Rezoning Transportation Analysis

Petition Number: 2021-132

Date	Description
09-17-2021	First Review (WLB)

The petition is located adjacent to Scaleybark Road, a City-maintained minor thoroughfare at Broadmoor Drive, a City-maintained local street. The petition is located in the South Wedge inside Route 4. Applicable area plans include the Park/Woodlawn Area Plan.

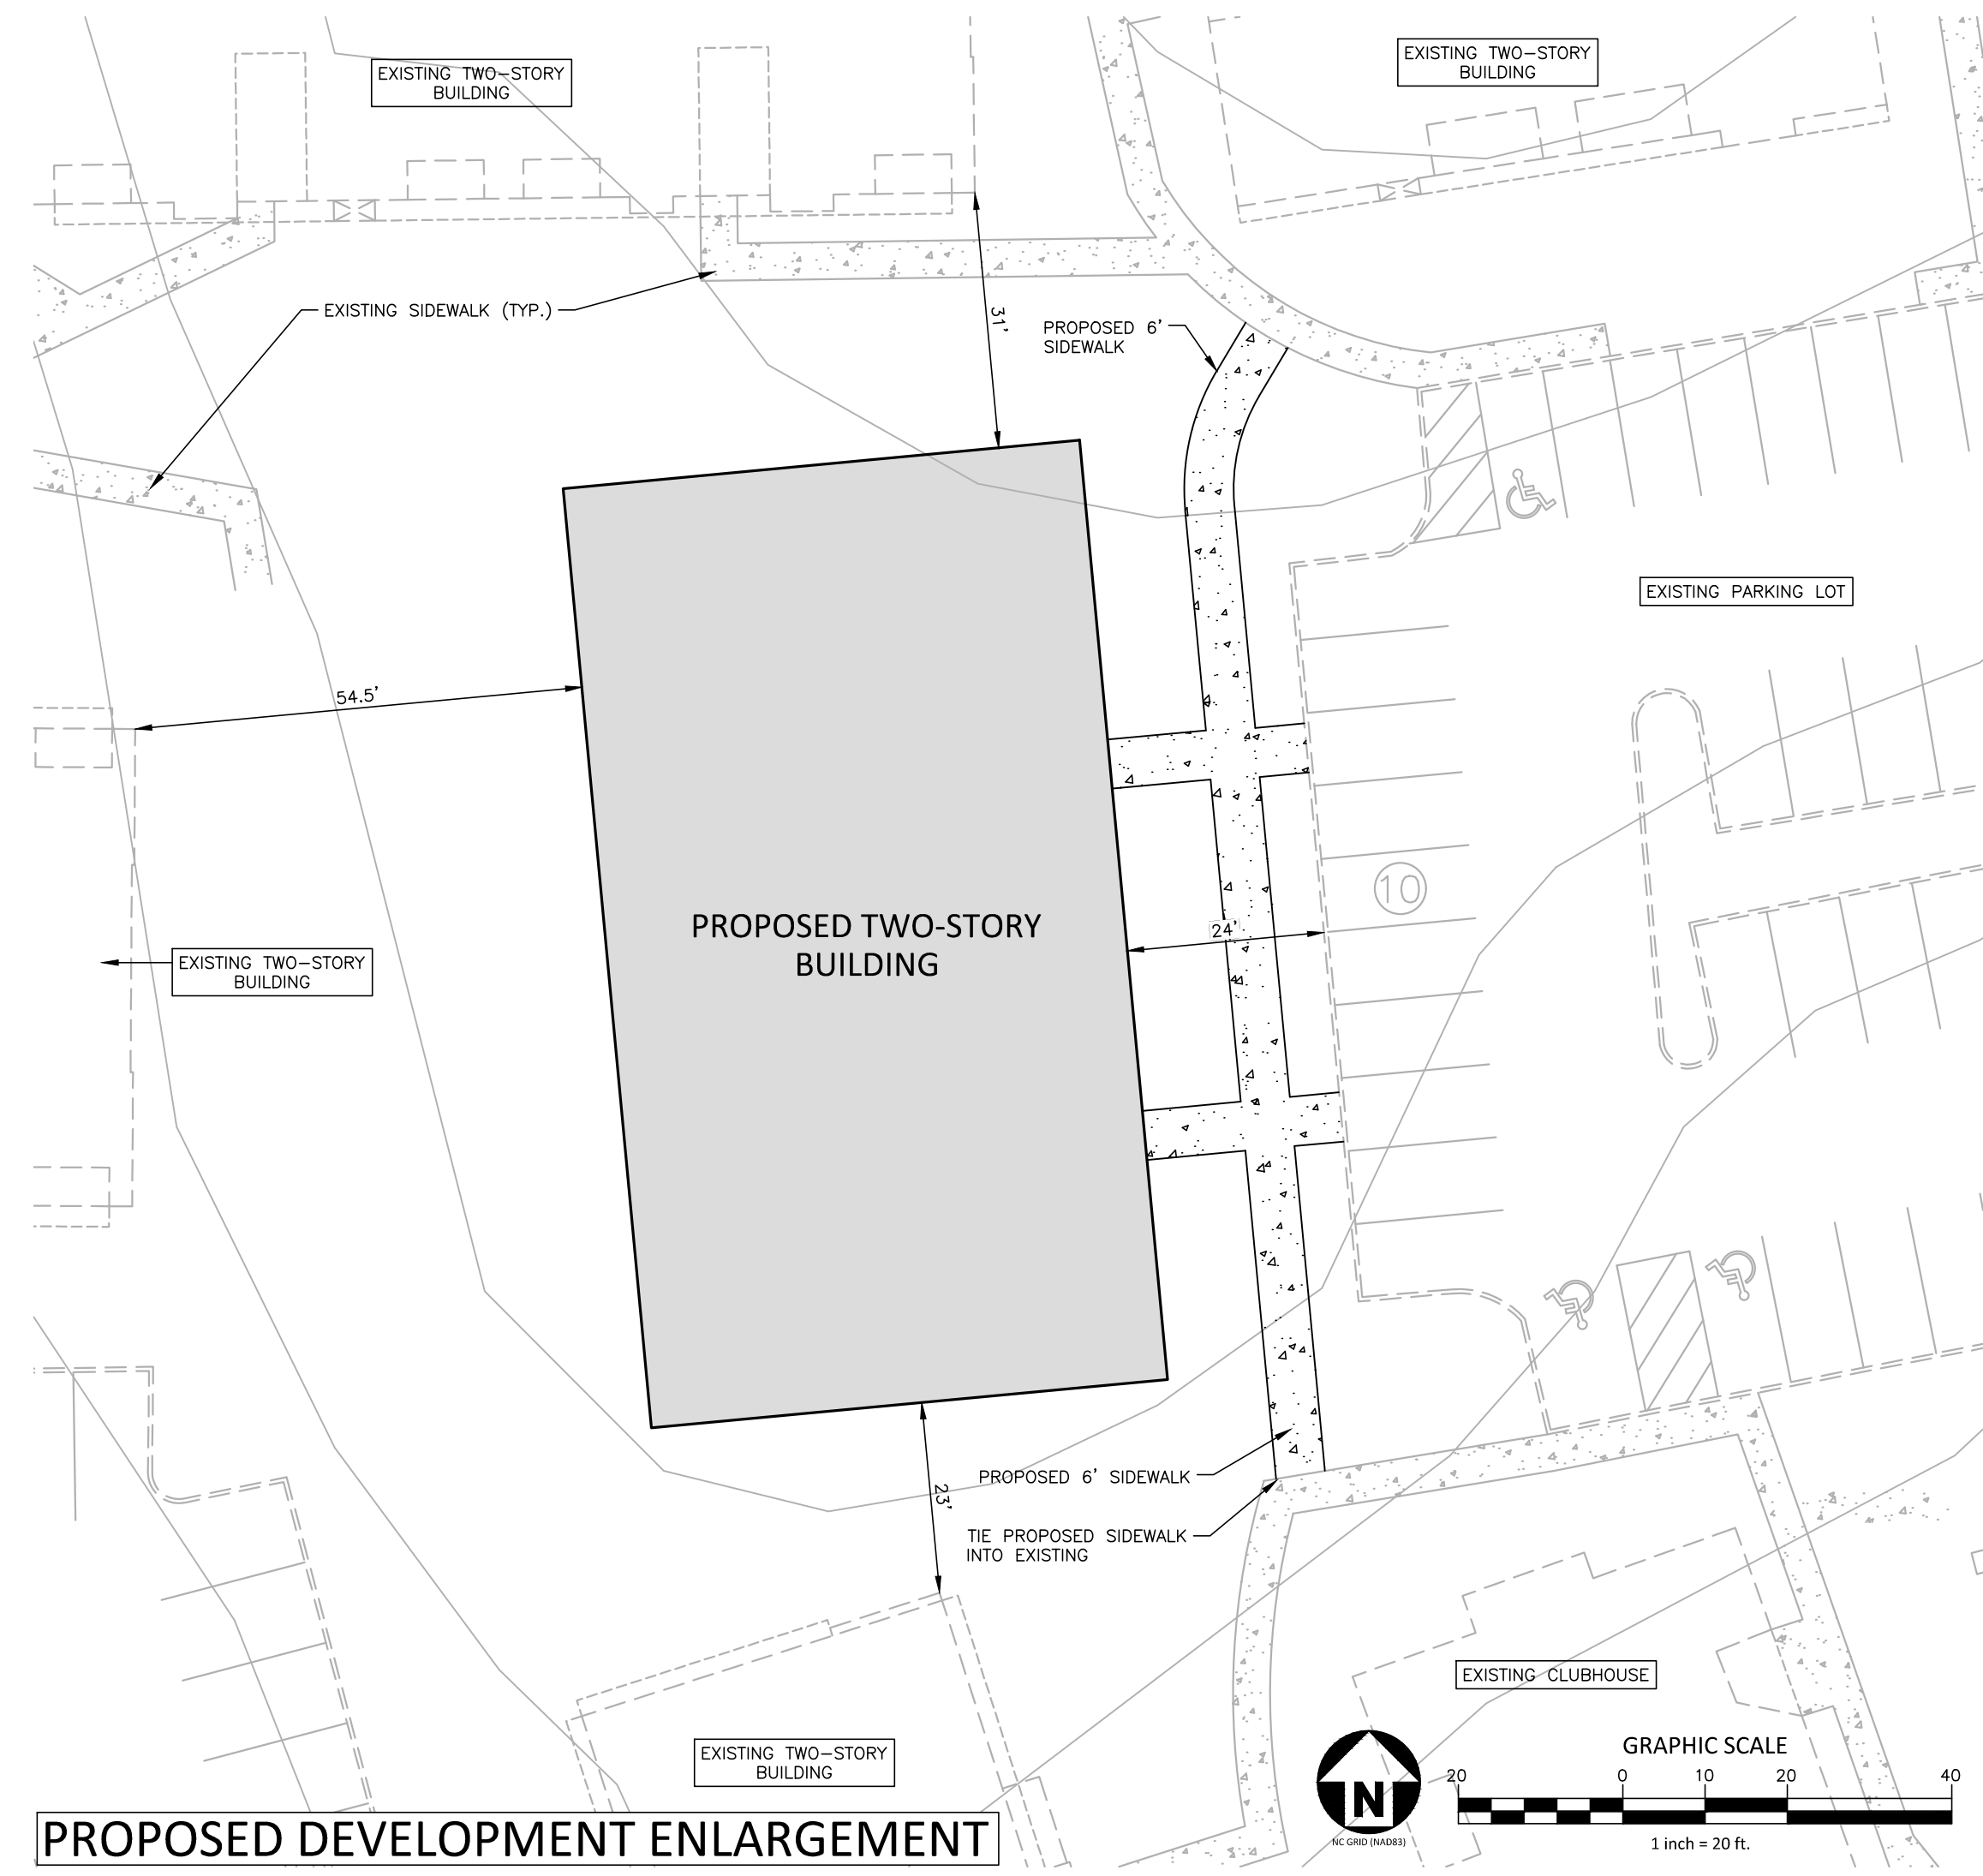
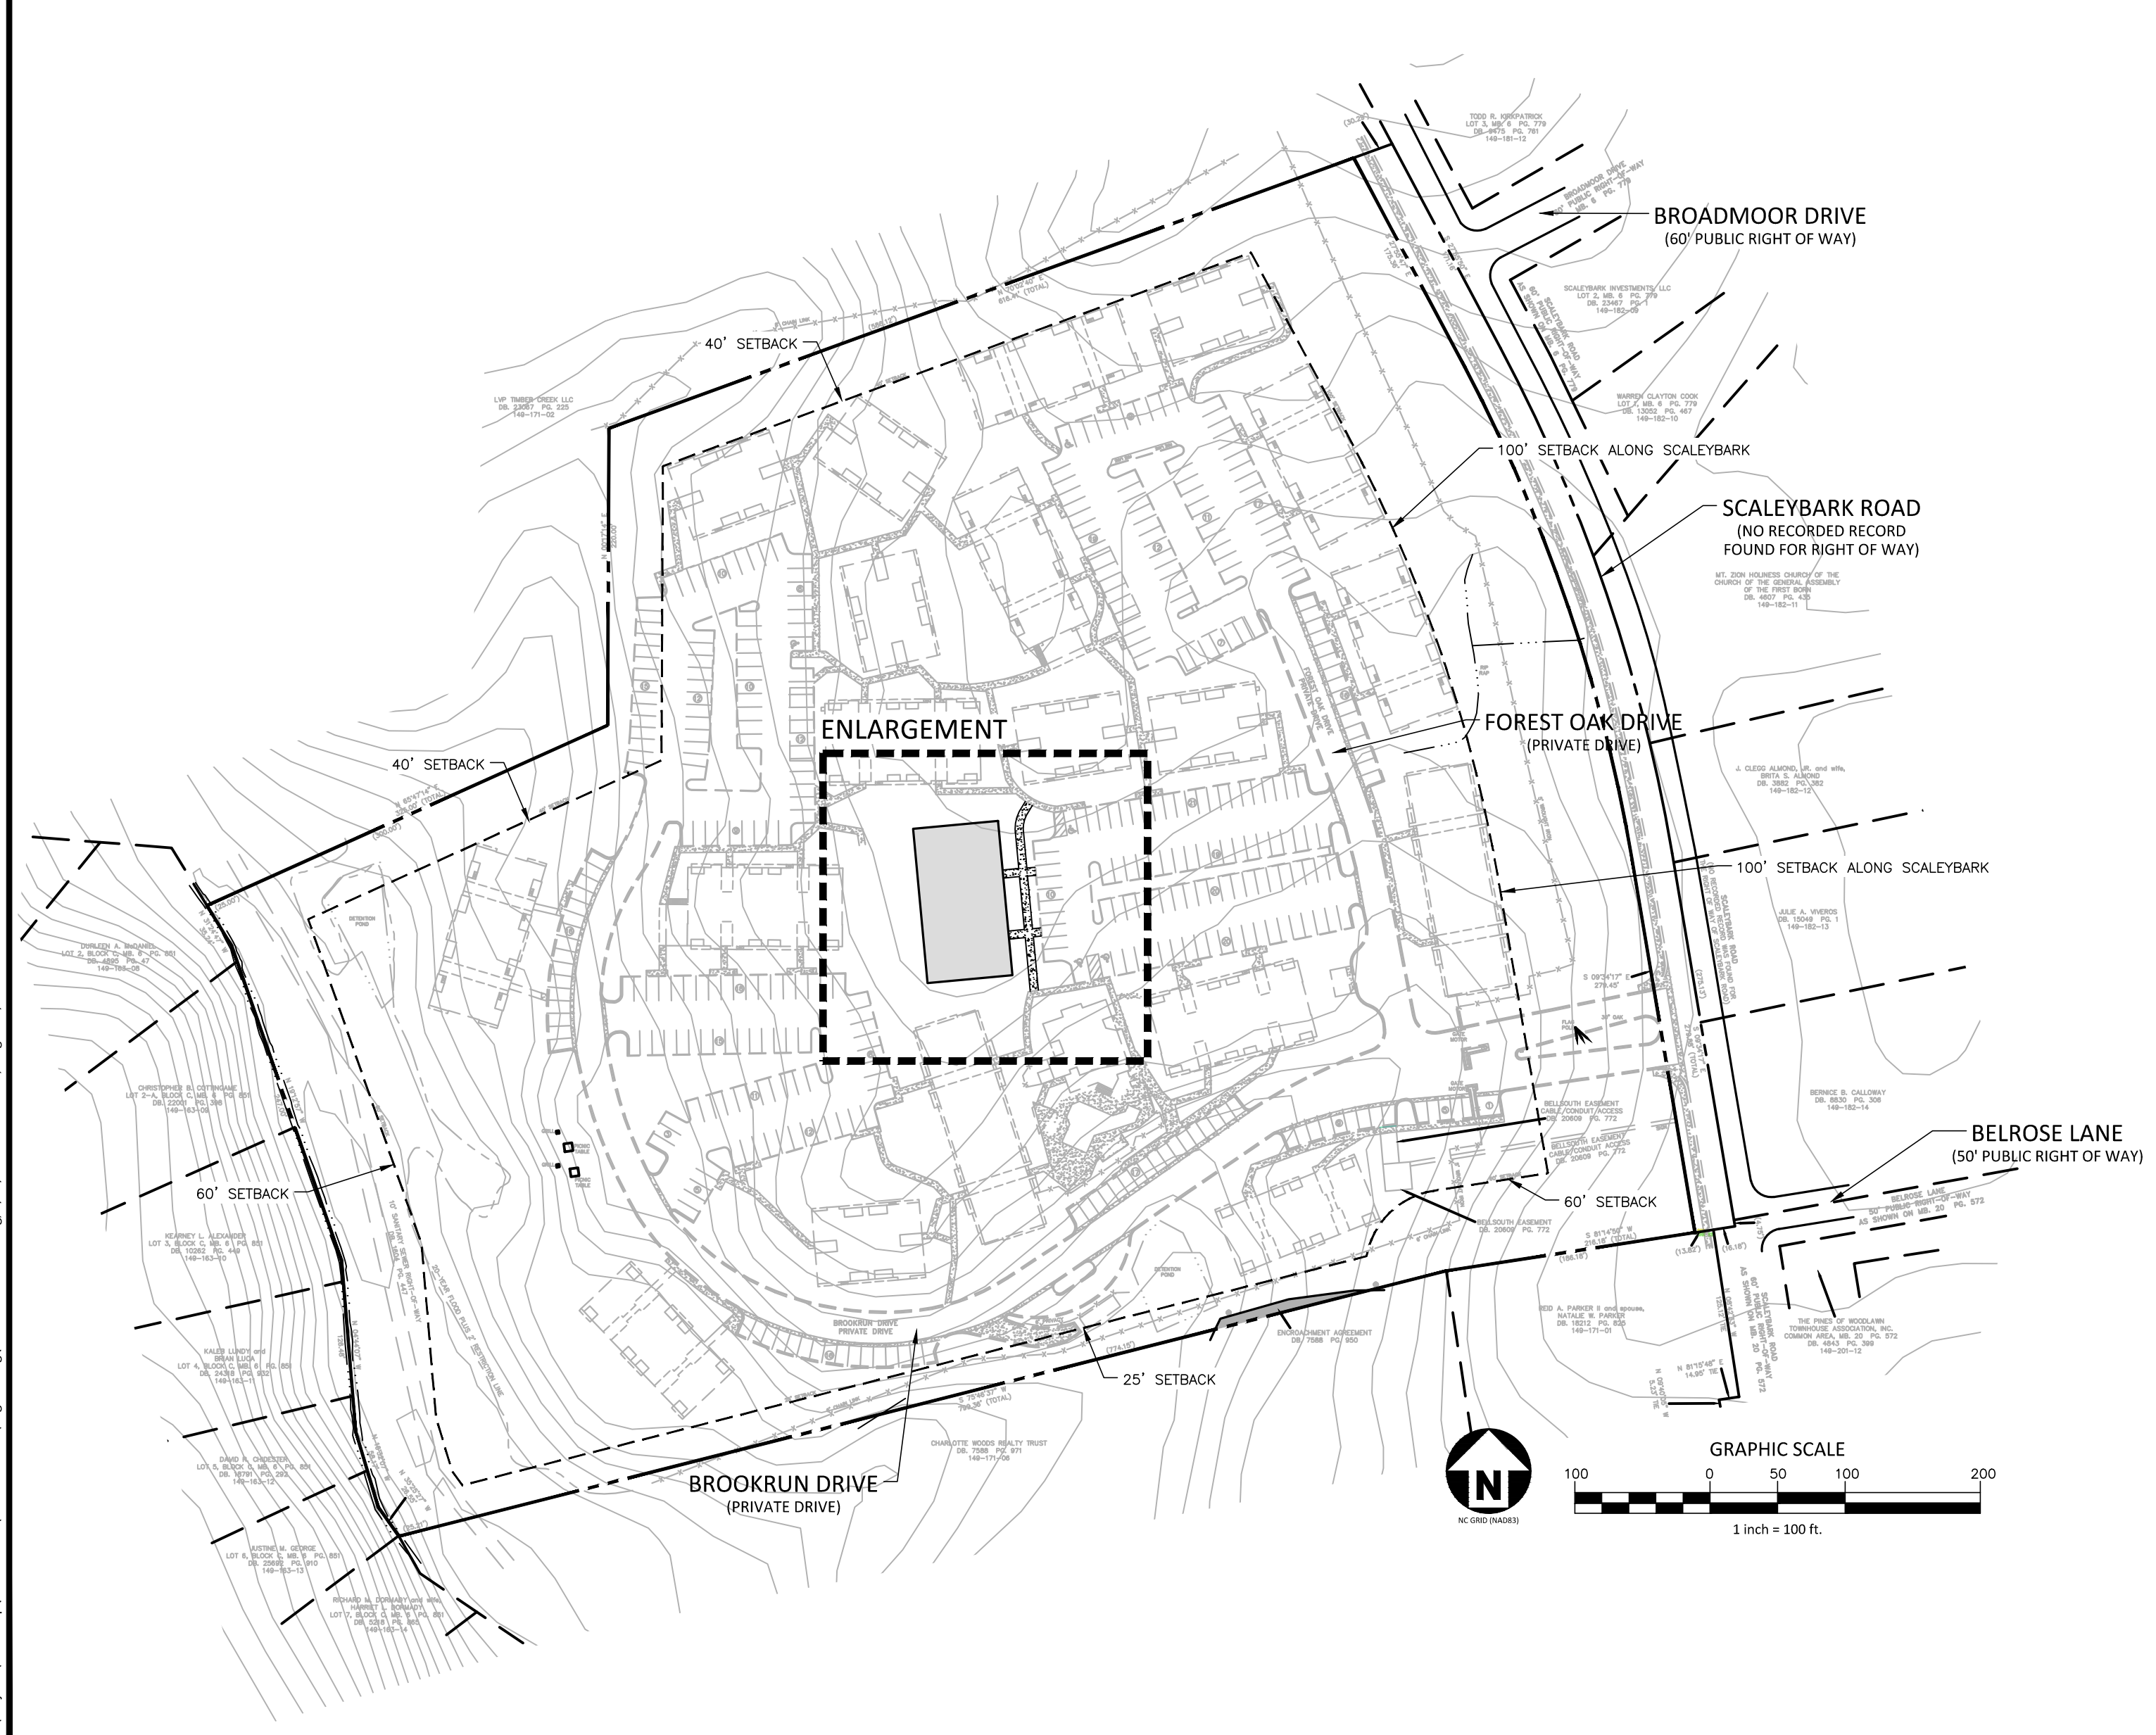
- a. **Scaleybark Road:** The future location of curb and gutter is in its existing location.

Label and dimension the curb and gutter from the centerline for each road on the site plan.

- 3. Revise site plan and conditional note(s) to commit to dedicate a 30-foot right-of-way from the Scaleybark Road centerline. The site plan shall label and dimension the right-of-way from the road centerline.
- 4. Site plan and conditional note(s) revisions are needed to provide ADA compliant crossing facilities on Scaleybark Road to include curb ramps on all quadrants of existing T-intersections (Broadmoor Drive and at the site's main entrance) and a pedestrian refuge per CLDSM 10.40 at the site's main entrance. The site plan shall label and dimension proposed facilities.

- 5. The proposed dwelling units exceeds 12 per acre. Per Chapter 20 Subdivision ordinance, site plan and conditional note(s) revisions are needed to commit to construct an 8-foot sidewalk with 8-foot planting strip along Scaleybark Road. The wider sidewalk meets the Charlotte WALKS Policy. The site plan shall label and dimension both items from the back of curb.
